EPC STORMWATER REVIEW COMMENTS
IN ORANGE BOXES WITH BLACK TEXT

**FINAL DRAINAGE REPORT
FOR
PLATTE SELF STORAGE
COLORADO SPRINGS, COLORADO**

MAY 2024

TNE Job No. 2419.00
County Job No. ###
Please include project No.
PPR2418

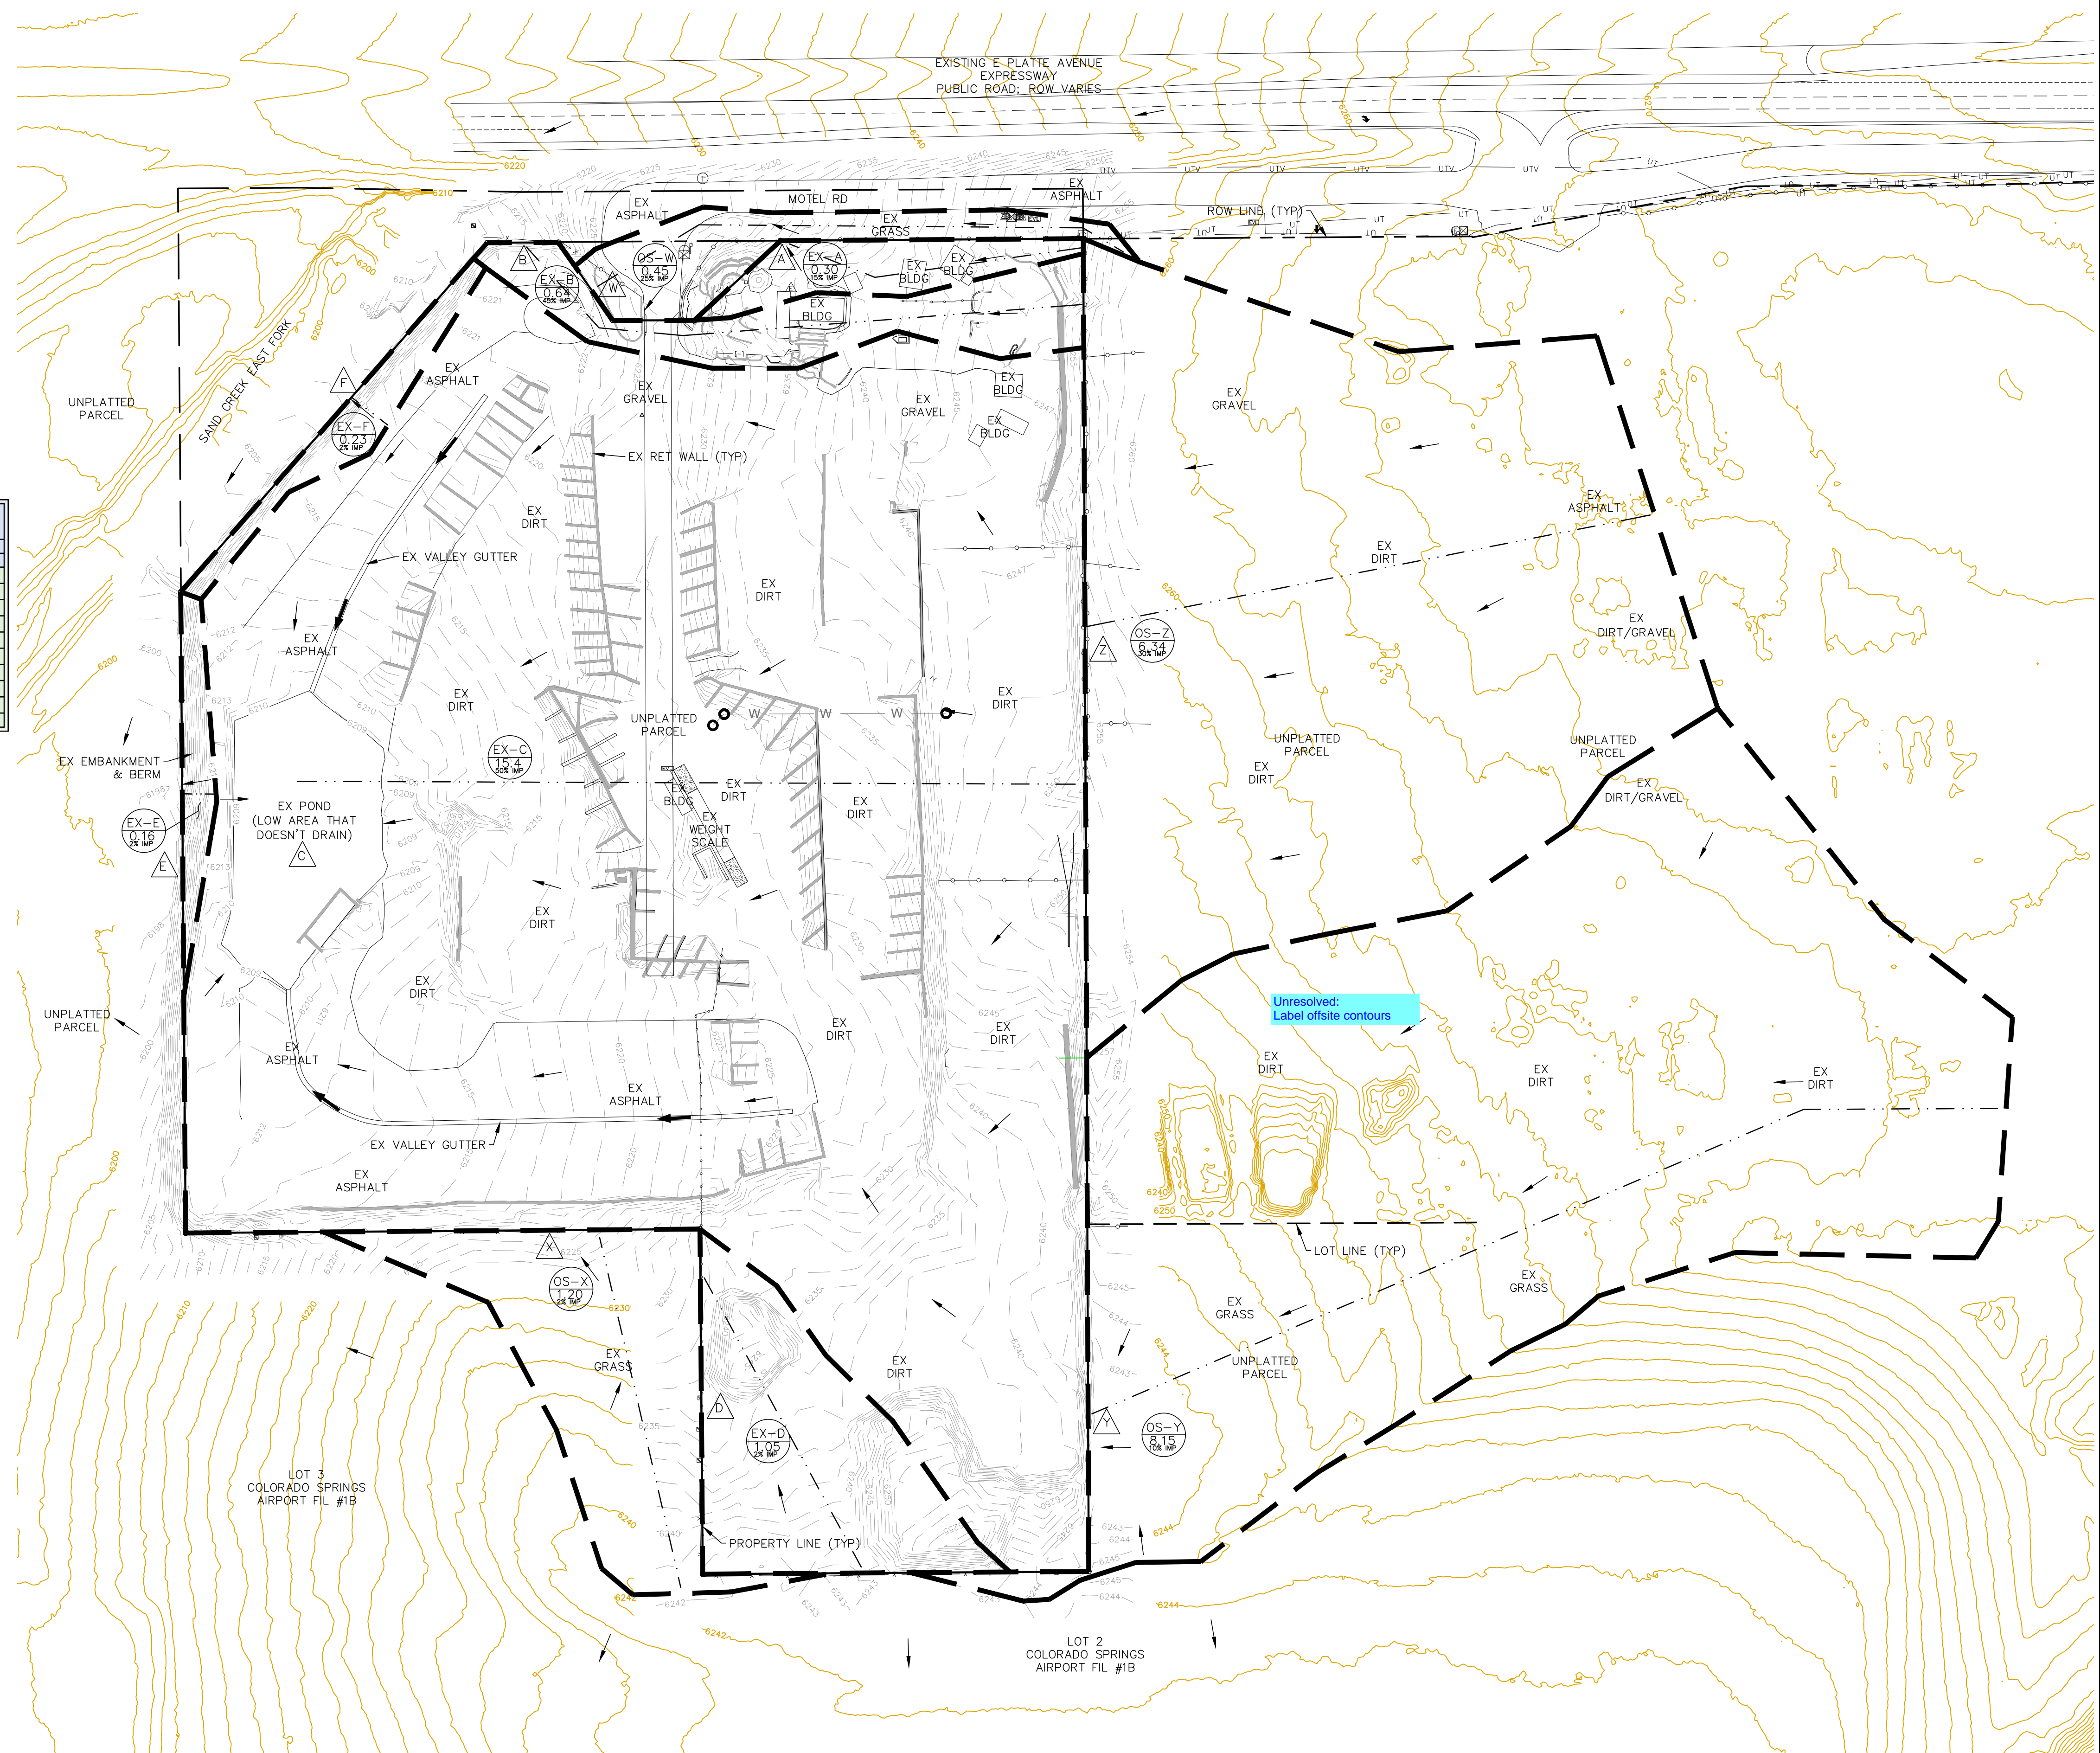
Please display more off-site contour 50'-200 feet beyond the boundary or drainage basin delineation line to illustrate how the runoff diverges from the site.

FINES RESPONSE:
Please see note 1. LIDAR contours are not accurate enough to confidently tie into survey contours. LIDAR contours are provided for context only and are not to be construed as exactly true or accurate to existing conditions.

FINES RESPONSE:
Offsite contours are already labeled.
